**WRITTEN SUBMISSIONS OF NFU AND LIG REGARDING THE NORFOLK VANGUARD
OFFSHORE WIND FARM DEVELOPMENT CONSENT ORDER 201 [...]**

PLANNING INSPECTORATE REFERENCE NO EN010079

**SUBMISSIONS OF NATIONAL FARMERS UNION AND THE LAND INTEREST GROUP ON
THE – ONSHORE ENVIRONMENTAL MATTERS ON 5 FEBRUARY 2019**

DATE 14th FEBRUARY 2019

Plate 5.16 Trench arrangement

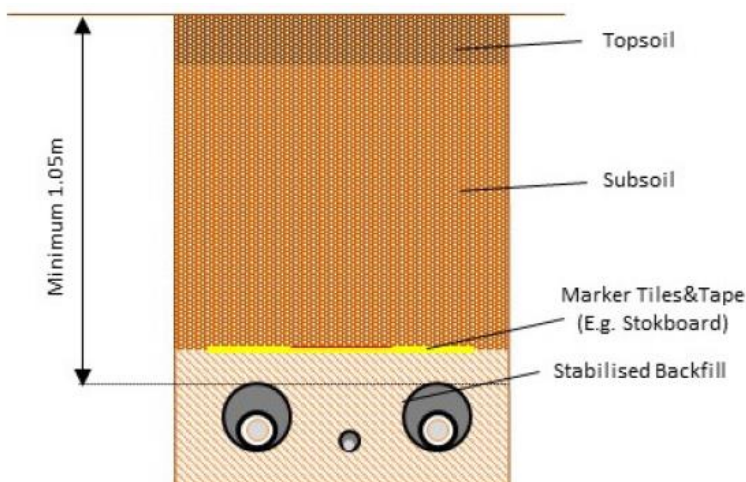
- Detail on how field drainage will be reinstated before the sub and top soil is reinstated on these 150m sections?
- When will the joint bays be constructed and what is the land area required for this construction?
- What happens if there is a fault on the cables during testing?
- When will the cables for the Boreas project be pulled through the ducts and the joint bays for this project be constructed?

Plate 5.23 Overview of main duct installation works process

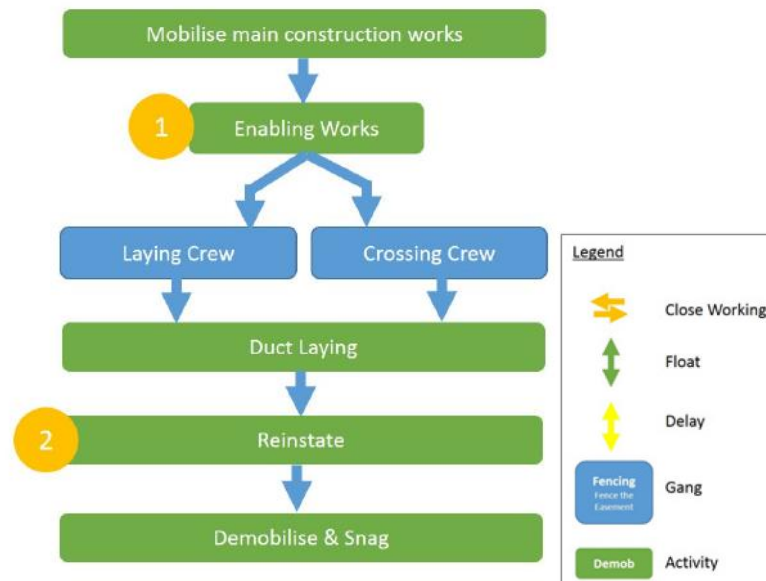
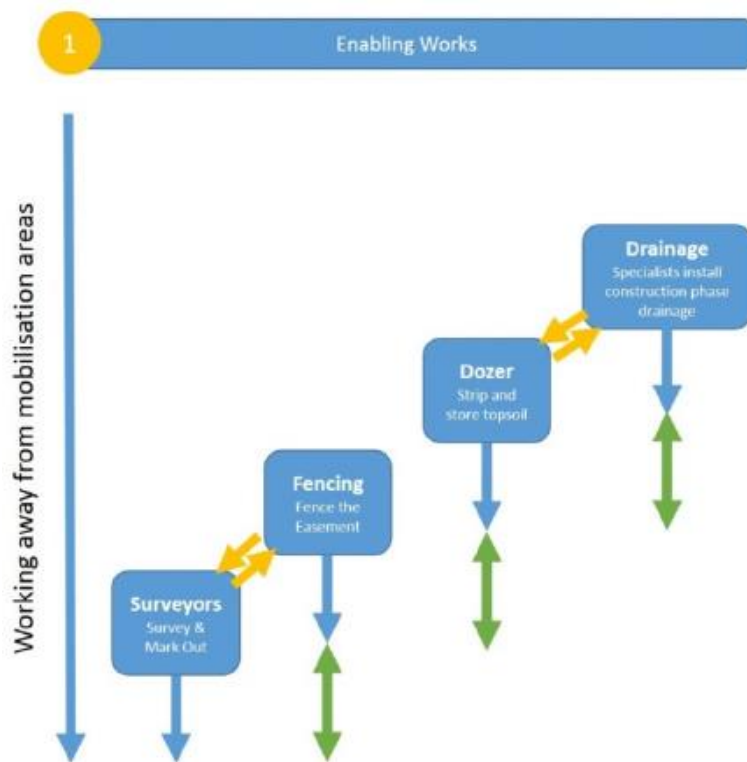
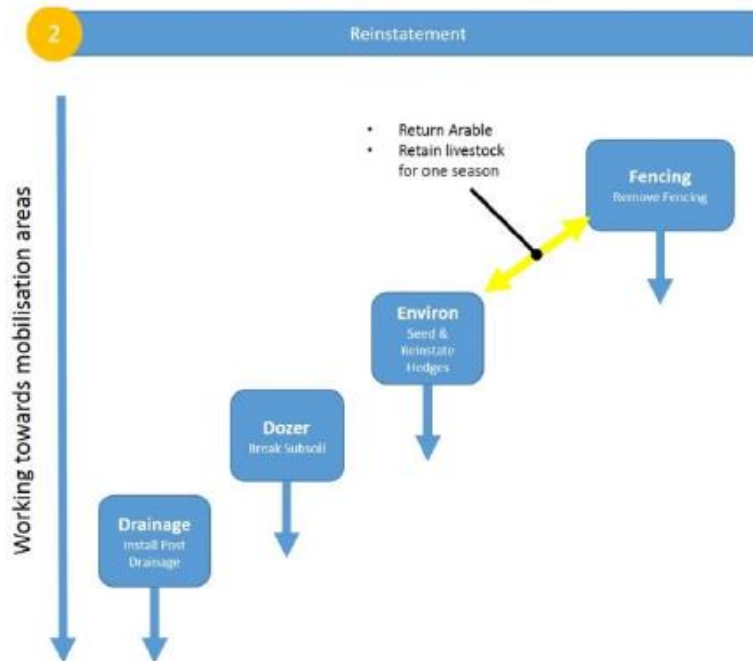
4.1 We understand from the voluntary discussions that the Applicant is intending to lay the ducts and reinstate approximately 150m sections at a time. This means that areas of land may be able to come back in to agricultural use within the second two year period when ducting is carried out. Further questions raised included:

- 9.0 Haul Road/Running Track:** The NFU and LIG would like further clarification on whether the running track will remain in place after the 150m sections of ducting have been reinstated or will the running track be removed at the same time? If it is to remain in place how long will this be for? It is not clear and there seems to be conflicting statements in Chapter 5: Project Description as well as the outline CoCP paragraph 2.5.5.
